CITY OF ALBUQUERQUE

December 19, 2018

**Re: Car wash Vacuum
500 Coors Blvd. NW
Traffic Circulation Layout
Engineer's/Architect's Stamp 12-15-18 (J10D041)**

SITE PLAN

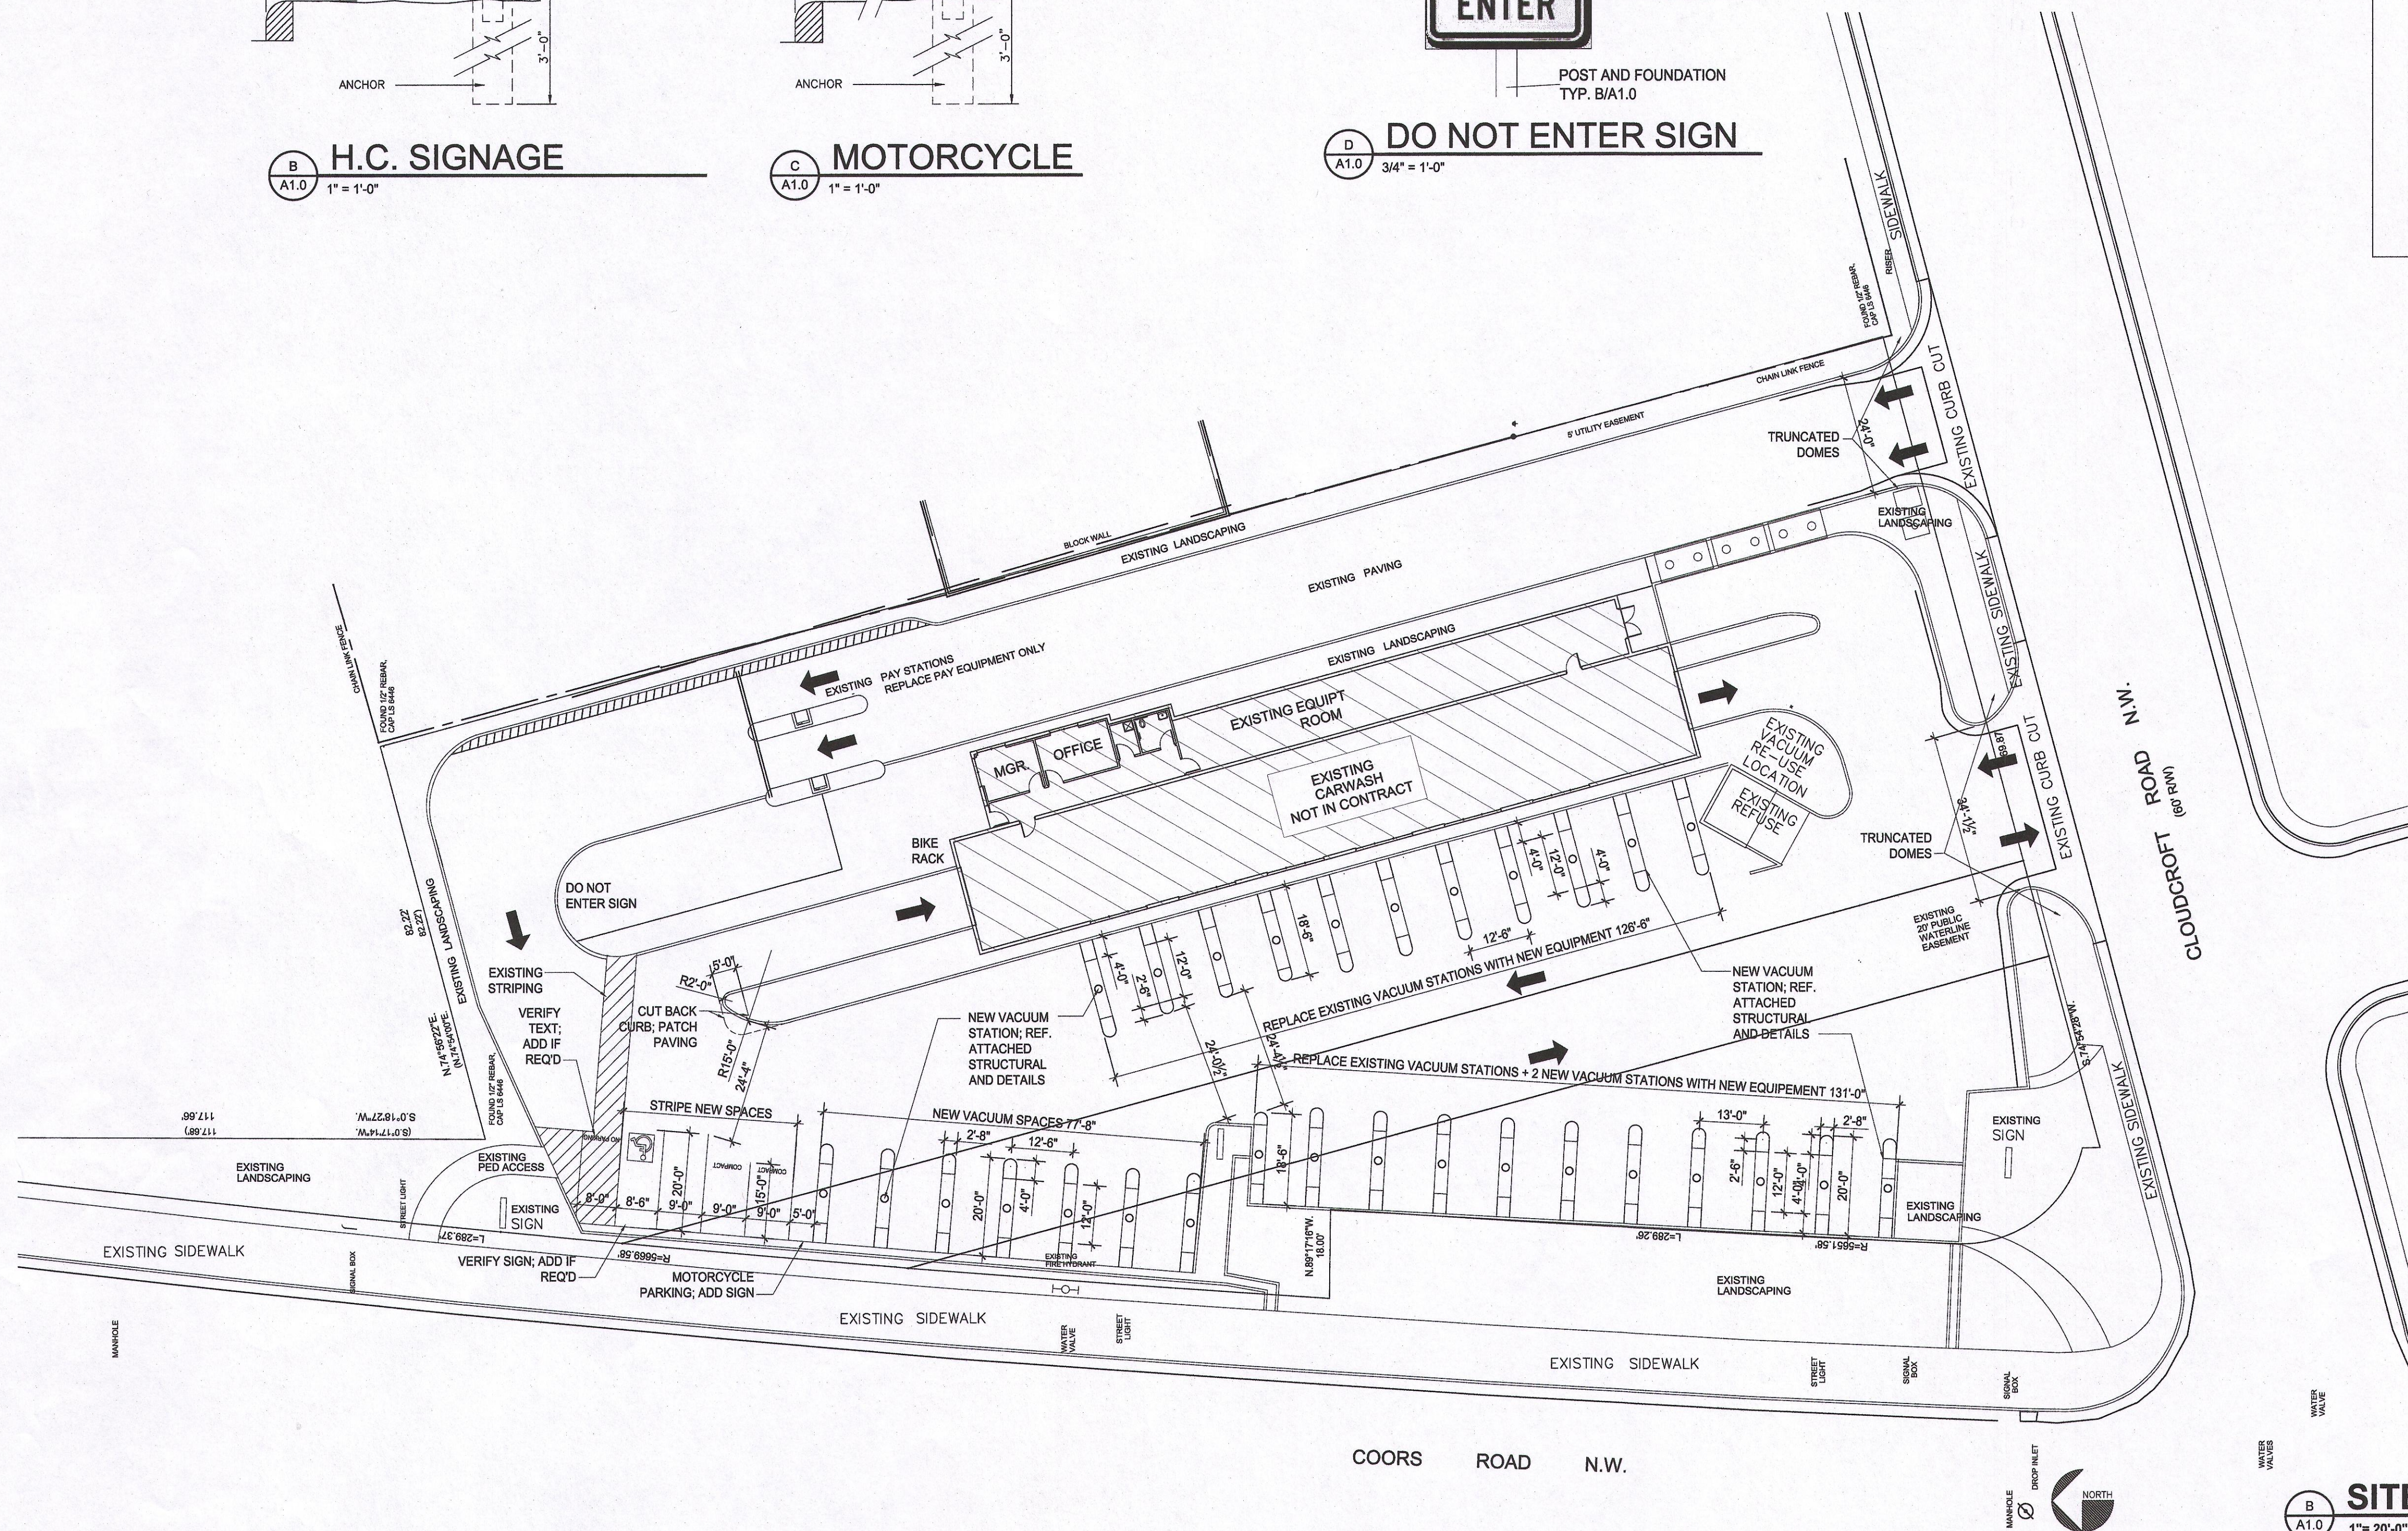
1. The ADA accessible parking sign must have the required language per 66-7-352.4C NMSA 1978 **"Violators Are Subject to a Fine and/or Towing."** Please call out detail and location of HC signs.
2. Note stating existing curb cut and note stating demo existing curb cut. Please clarify.
3. New curb cut not to exceed 30'. Extend landscaping west towards Coors Blvd.
4. Please specify the City Standard Drawing Number when applicable.
5. Indicate ramps and truncated domes on both access entrances and exits.
6. List radii for all curves shown; for passenger vehicles, the minimum end island radius for passenger vehicles is 15 ft. Radius for delivery trucks, fire trucks, etc. is 25 ft. or larger.
7. Where replacing existing vacuum stations fronting Coors. Google image shows 8 vacuum stations. TCL plan indicates 10 vacuum stations, please clarify.
